RE: Response to exhibition of the Historical Heritage Assessment and Statement of Heritage Impact for proposed New England Solar Farm, Uralla Shire LGA (SSD 9255)

- Report, 'New England Solar Farm, Historical Heritage Assessment and Statement of Heritage Impact', prepared by EMM for UPC Renewables Australia Pty Ltd, dated 16 November 2018.

14 March 2019

New England Solar Farm
Historic heritage assessment
and statement of heritage impact
Figure 7.1

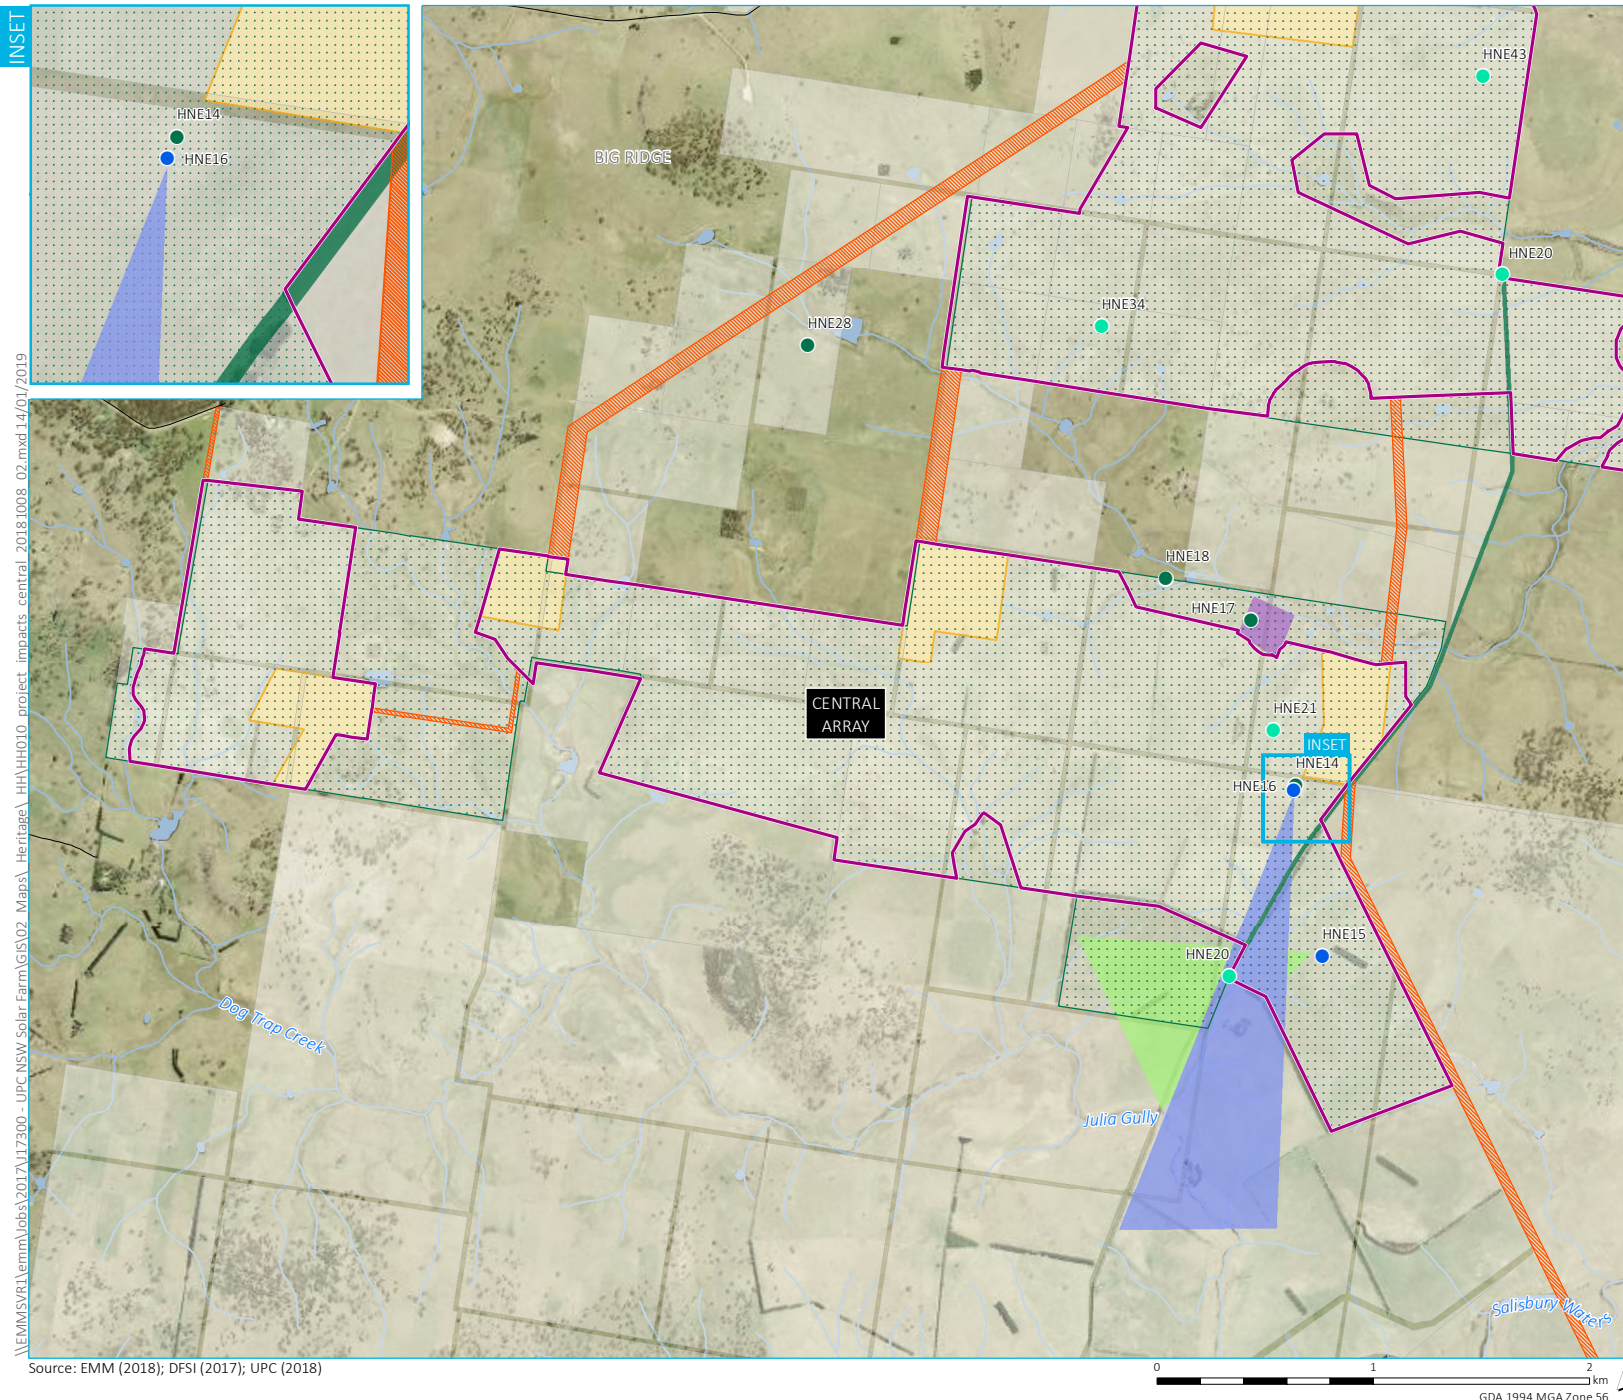
The assessment identified and assessed existing local and State significant archaeological sites. Impacts on the known sites, Shepherd's Hut (HNE17) and House Site (HNE19) have been mitigated through revisions of the development footprint for the central and northern array areas, thereby enabling their continued conservation. A survey of the third known site, the Stockyard (former) (HNE26), dating to approximately c1867, reveals no physical evidence at the site. Should archaeological remains be uncovered during the project work the assessment indicates they would likely consist of post holes, nails and timber fragments. The assessment of impact to this site is considered to be moderate, with no test excavation proposed as the significance of the site does not warrant this type of investigation. It is noted however, that if evidence of the Stockyard is located during Aboriginal test excavation, any archaeological remains will be archivally recorded. It is further noted that this investigation would be completed either through the public exhibition of the EIS or in preparation of the RtS report.
